Office of
Environment
& Heritage

RE: REVIEW OF EXHIBITED ENVIRONMENTAL ASSESSMENT FOR MANDALONG SOUTHERN EXTENSION PROJECT (SSD-5144)

REVIEW OF EXHIBITED ENVIRONMENTAL ASSESSMENT FOR MANDALONG SOUTHERN EXTENSION PROJECT (SSD-5144)

Groundwater Hydrographs – Mandalong Alluvial Bores

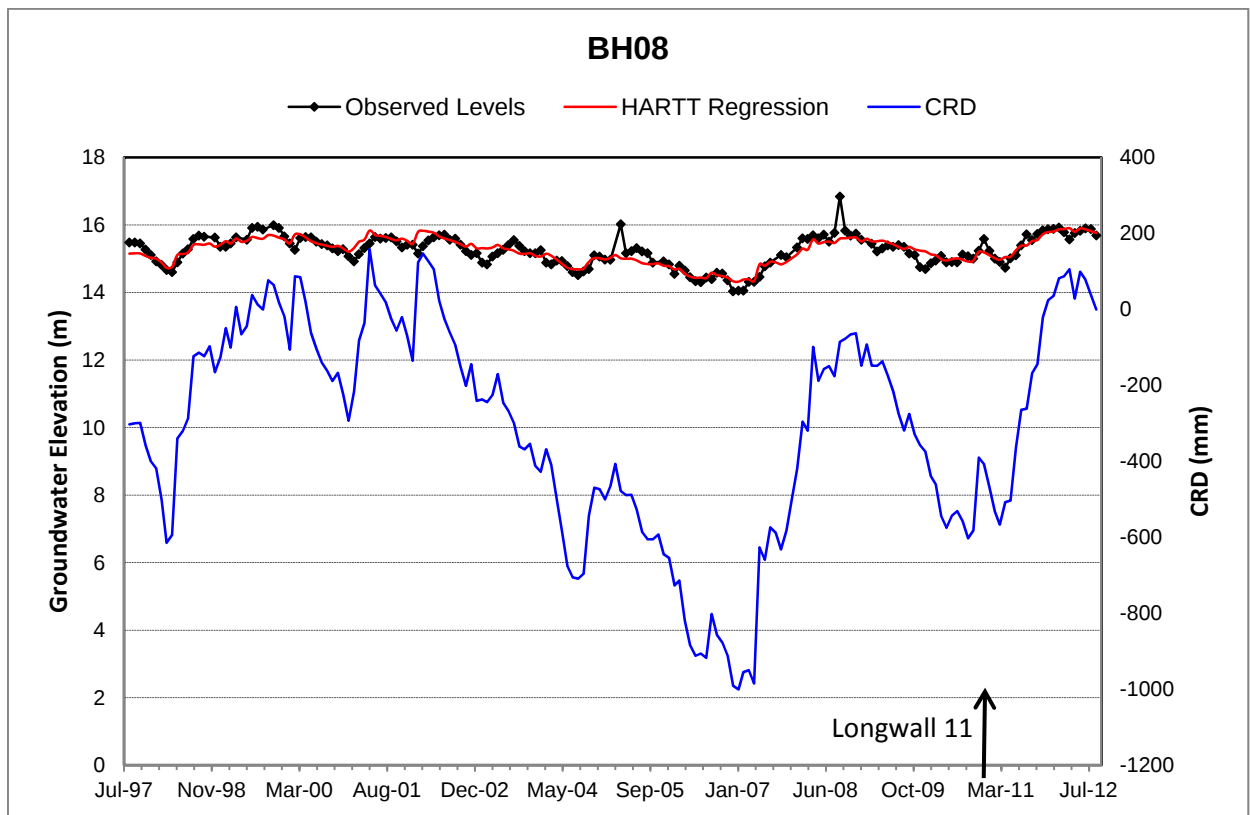
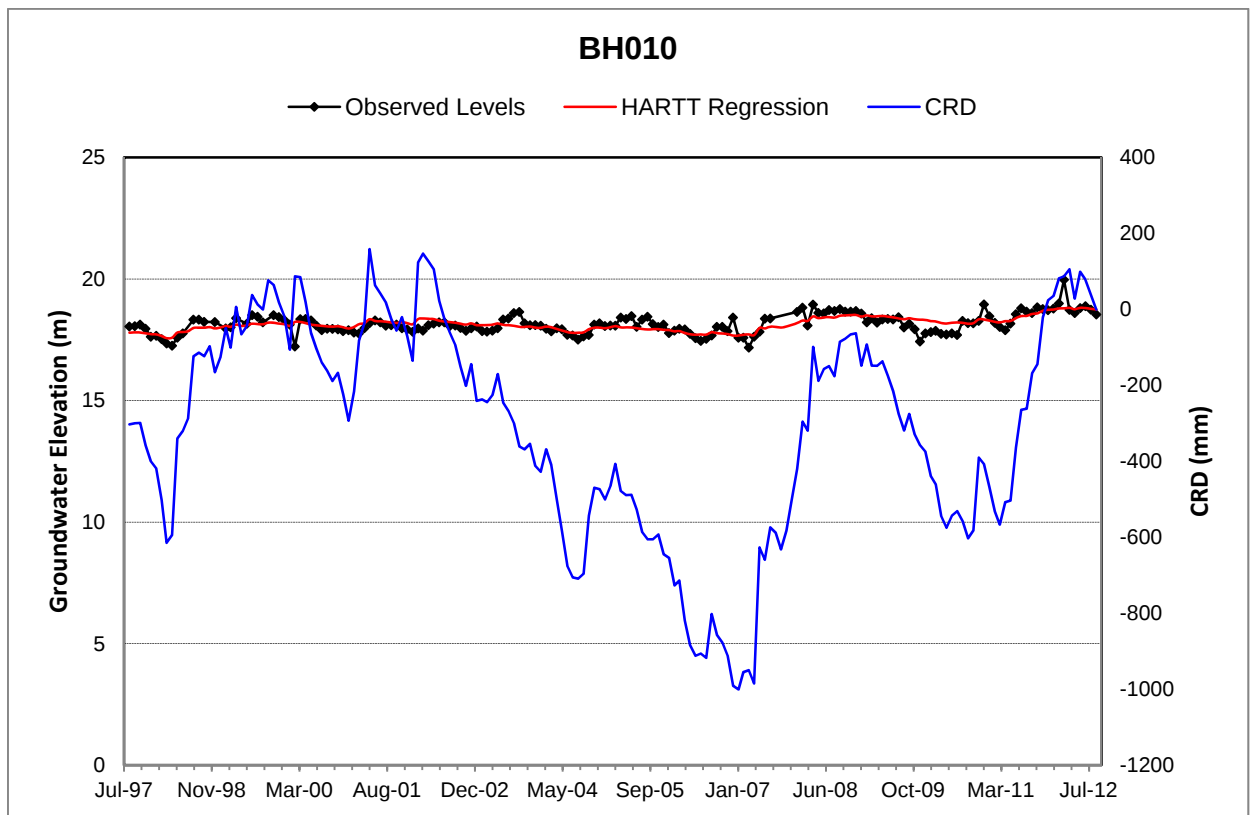
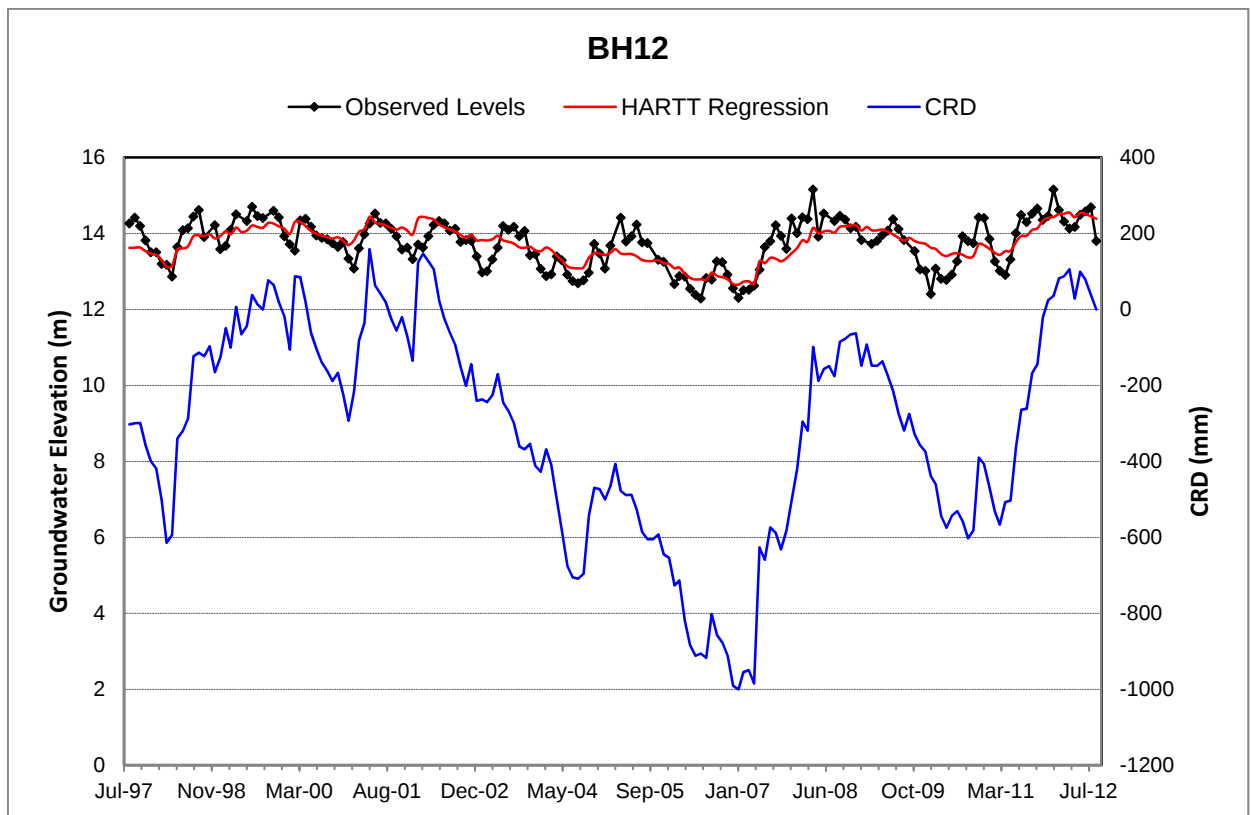
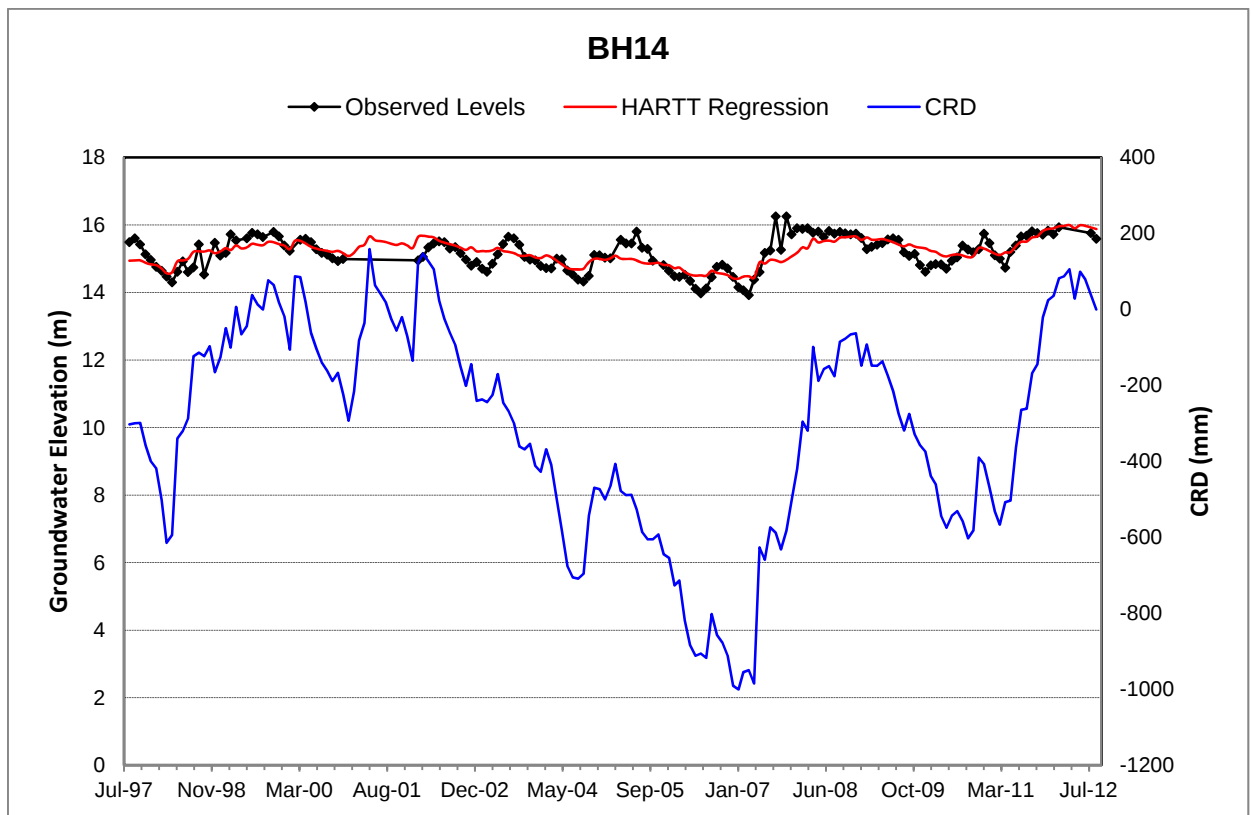
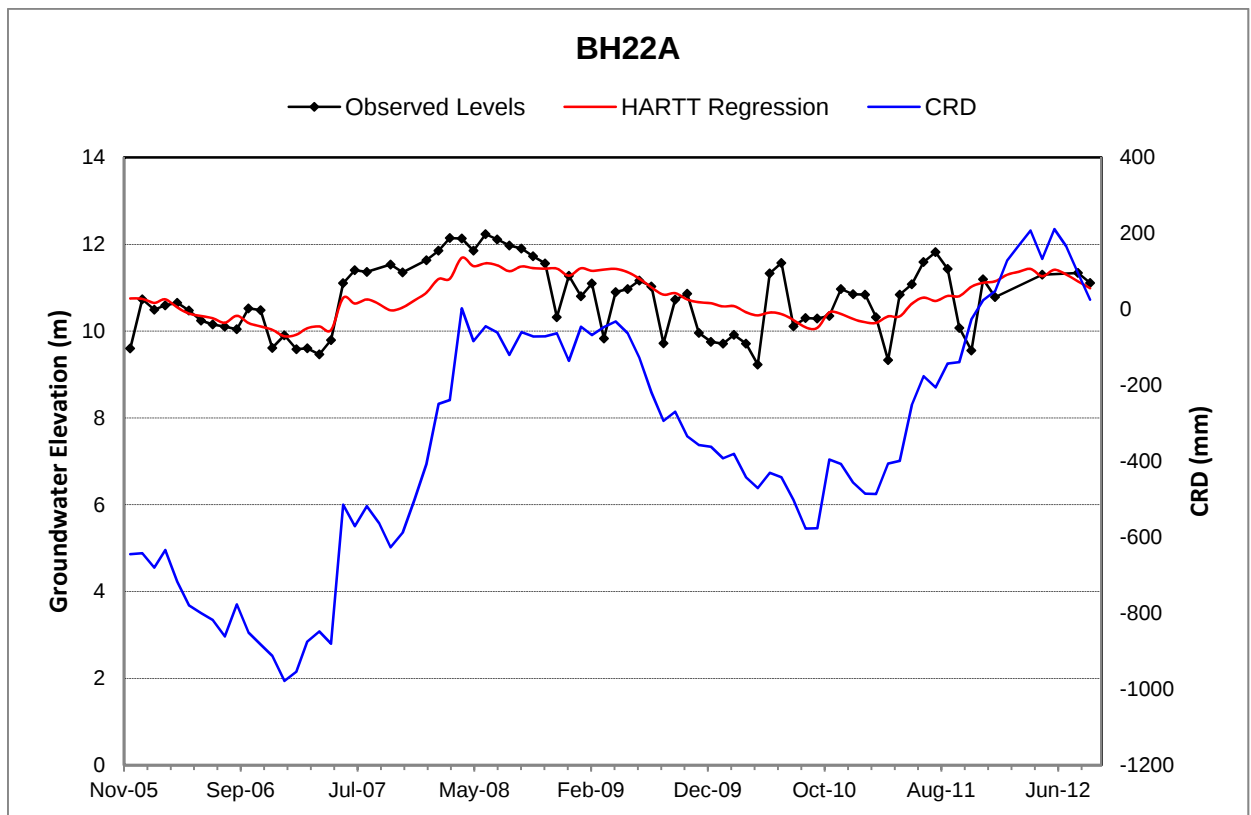
- impacts to aquifers at the 30-50m levels (eg BH17, BH21, GWB22B – see Figure 1)
- the increase in panel widths to 200m
- width to depth ratios approaching or exceeding unity
- location of faults and geological structures within the project area
- interaction between faults and groundwater levels (see Figure 1).

For these reasons, OEH believes a detailed review of the potential for surface to seam (or GDE aquifer to seam) fracturing and complete groundwater drainage is required prior to any approval of the current mine plan.

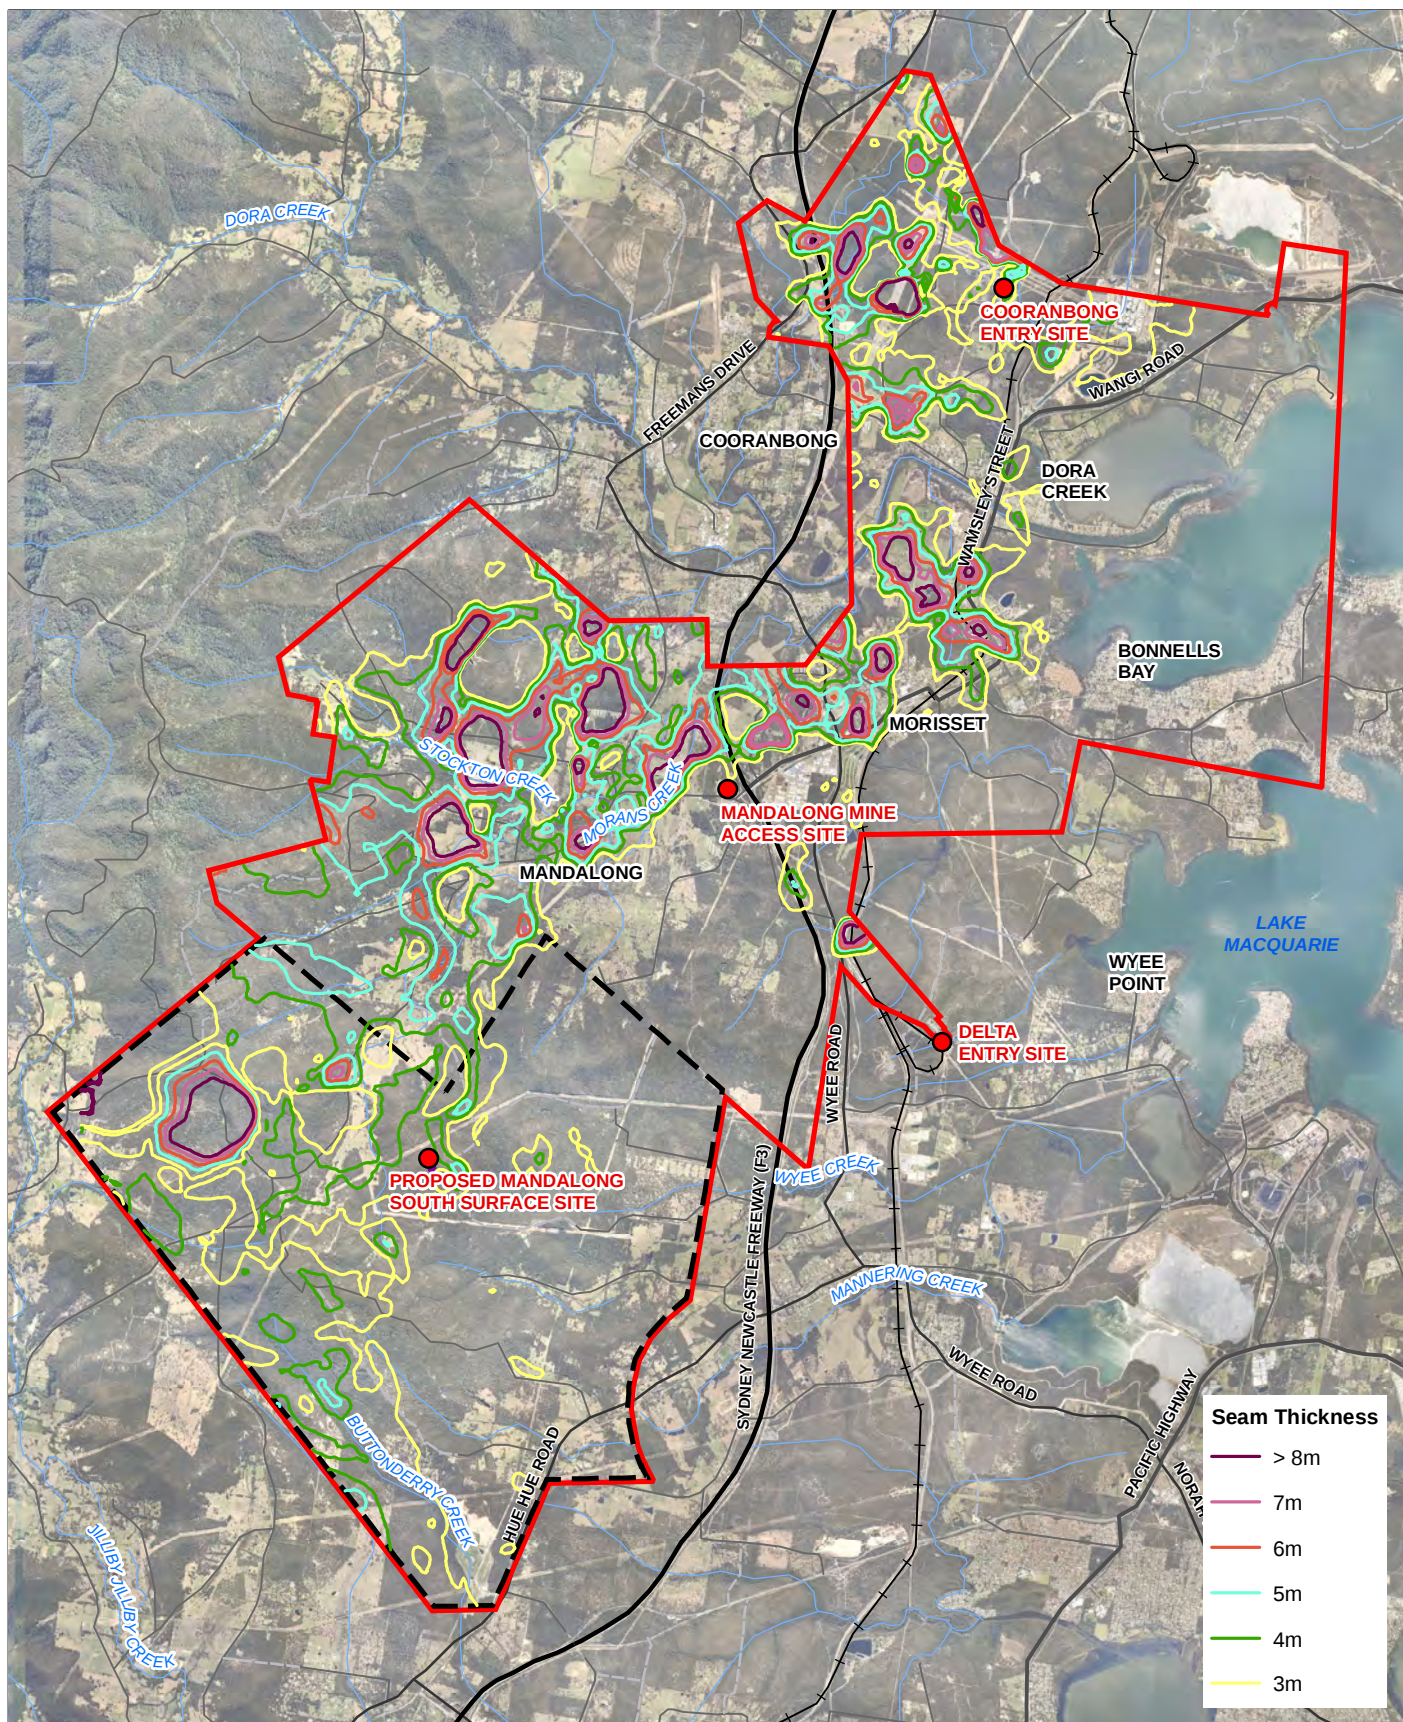
OEH notes that an **average** fracture zone (not a maximum) has been used in the groundwater modelling. In response to previous problems in the Newcastle coalfields affecting (draining) creeks, OEH notes that a specific assessment of the potential hydraulic connection of longwall mining was undertaken for Bowmans Creek for the Ashton Mine proposal (SCT 2008). SCT (2008) found that the height of cracking above the extraction panel typically extends 1-1.5 times the panel width². It was found that the extent of cracking and interconnection potential above the extraction panels increases with increasing subsidence. If SCT's (2008) worst case scenario of height of cracking 1.5 times panel width is applied to Mandalong mine layout then for many longwall panels (particularly those with the shallower depth of cover) cracking is suggested to reach the surface. Even if a more conservative estimate (height of cracking equals panel width) is applied, cracking is still suggested to reach the surface in some areas of the mine plan. SCT (2008) recommended a conservative approach to undermining the Bowmans Creek alluvium maintaining width to depth ratios of 0.6 – 0.7. Many of the width to depth ratios for the Mandalong extension are much greater than this and in some cases exceed unity ($w/d > 1$).
